# CITY OF ALBUQUERQUE

**Re: Temporary Construction Entrance for Del Webb @ Mirehaven Phase I  
Grading and Drainage Plan  
Engineer's Stamp Date 10-7-14 (H09D017C)**

CITY OF ALBUQUERQUE
DEPARTMENT OF
MUNICIPAL DEVELOPMENT
DEL WEBB @ MIREHAVEN PHASE 1
GRADING PLAN

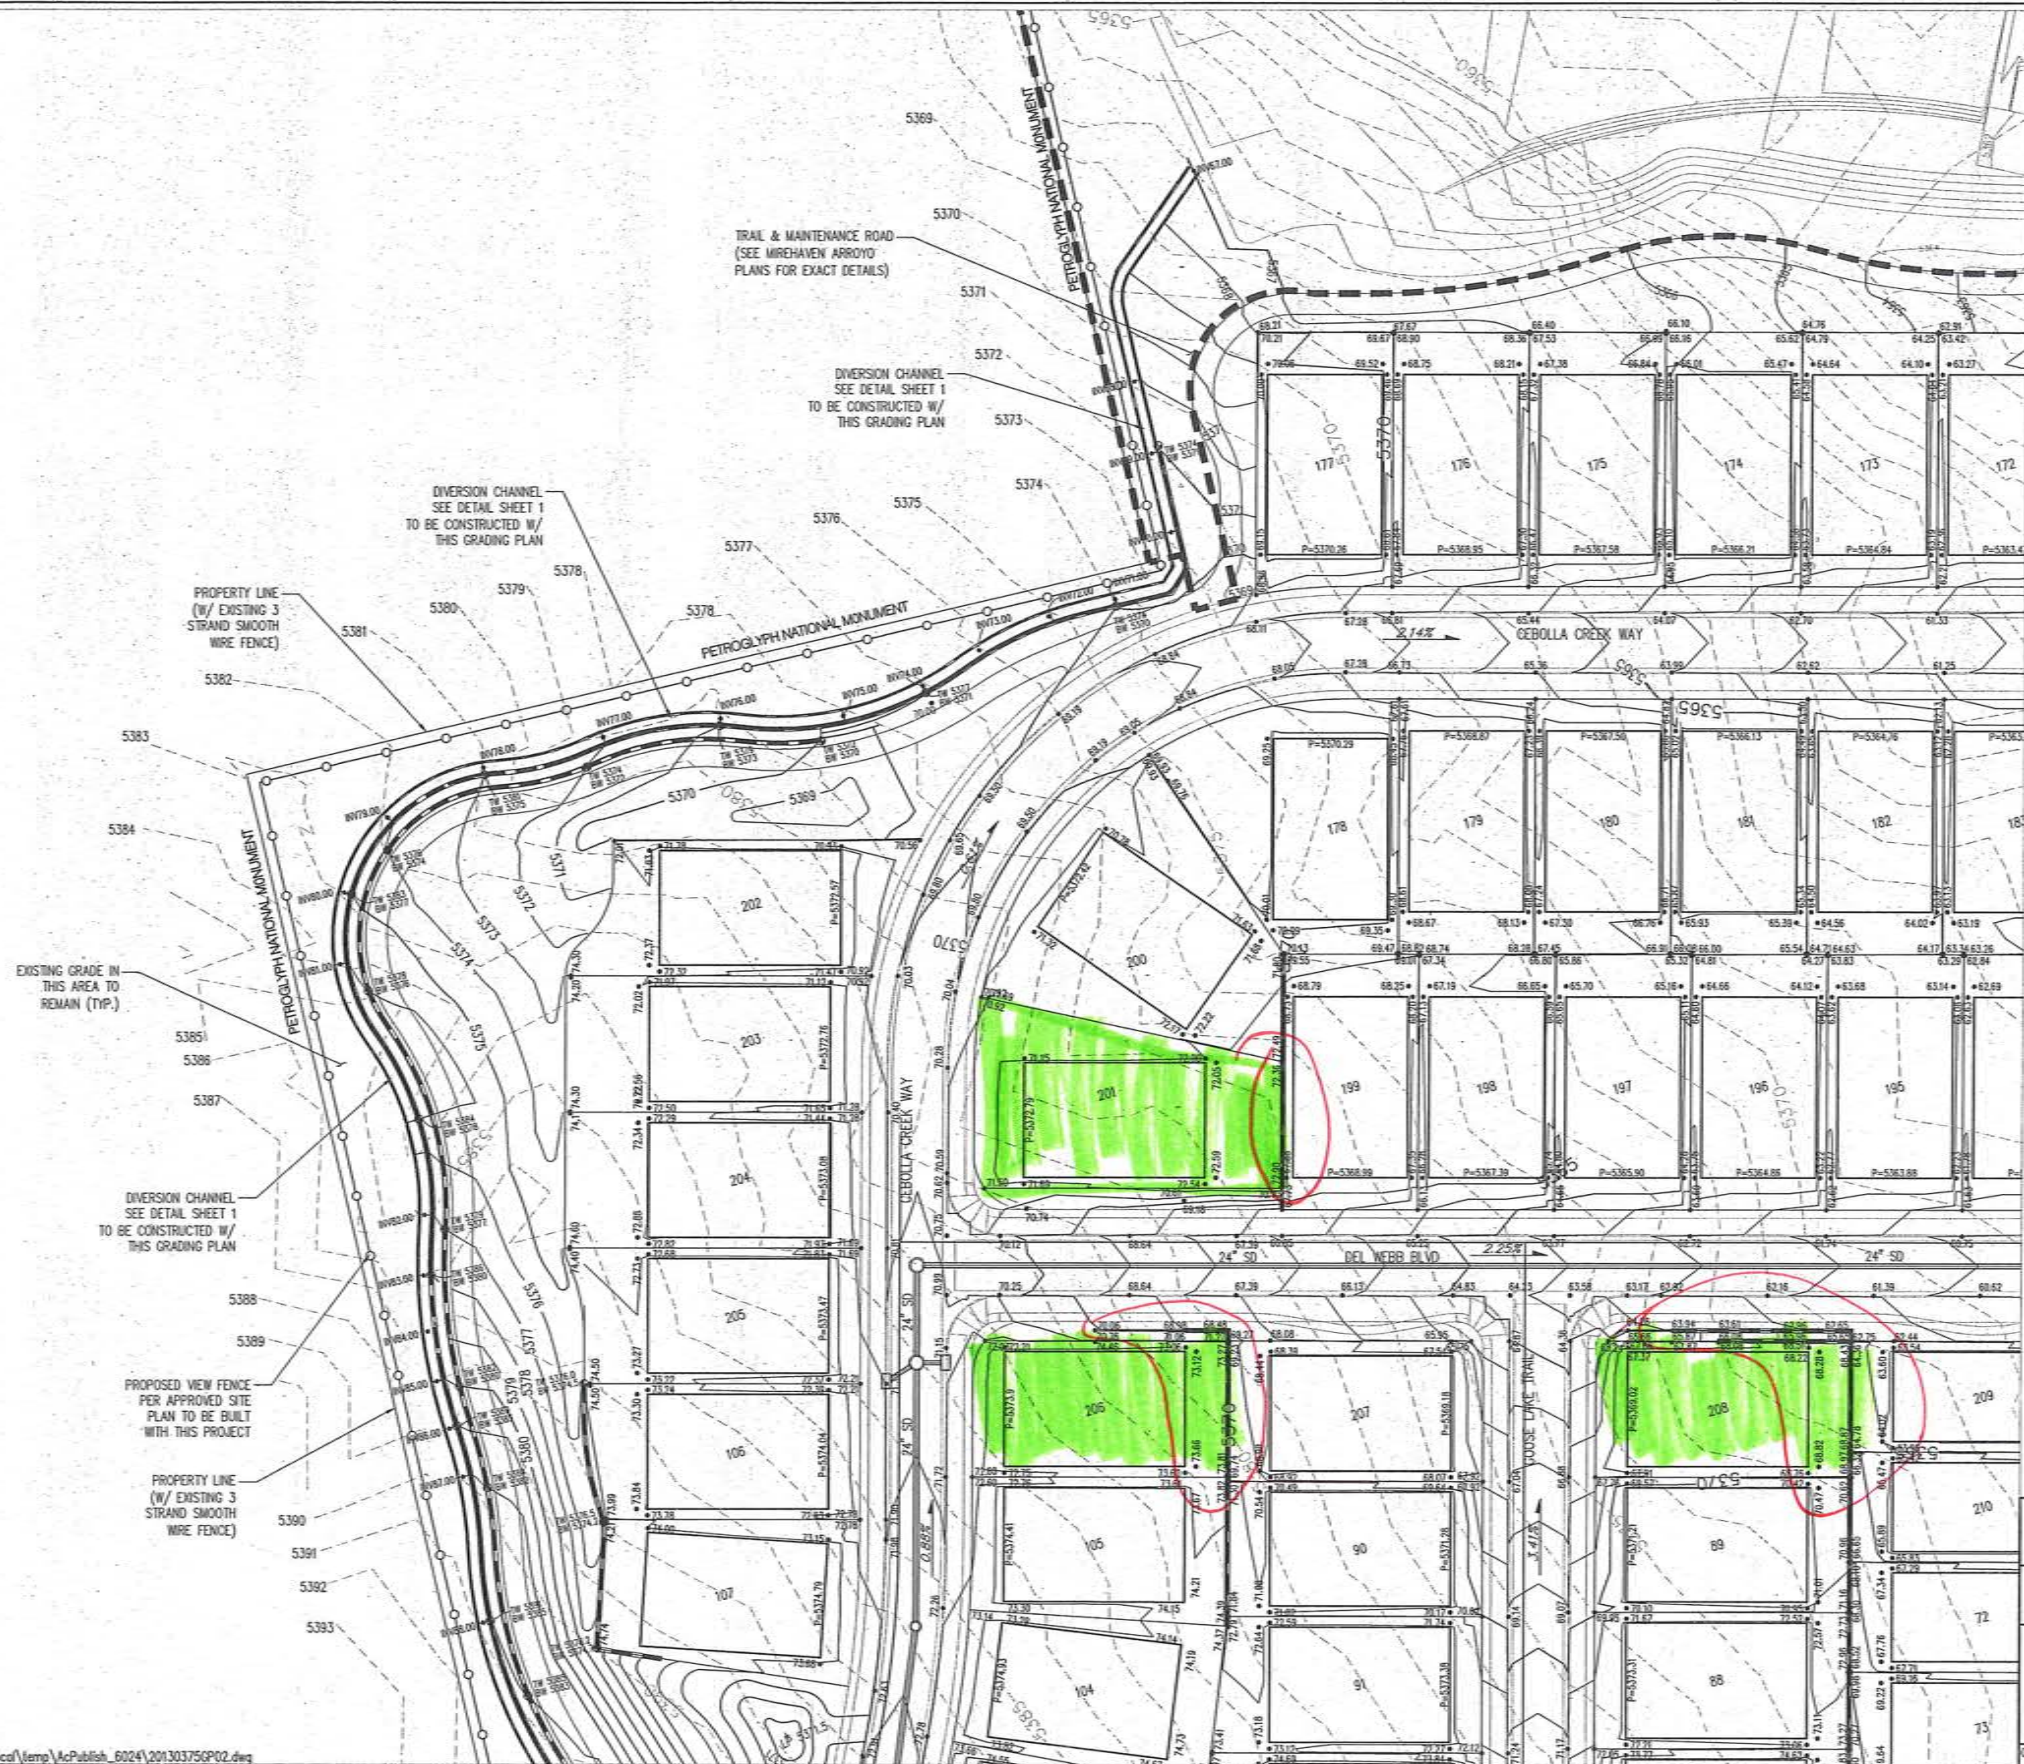
1. The temporary construction road and rock do not go all the way to Willow Canyon Trail. Please revise so that the temporary road is connected.
2. Extend the rip-rap more around the outlet of the proposed 24 inch CMPs.
3. Update the Erosion Control and Sediment Plan.
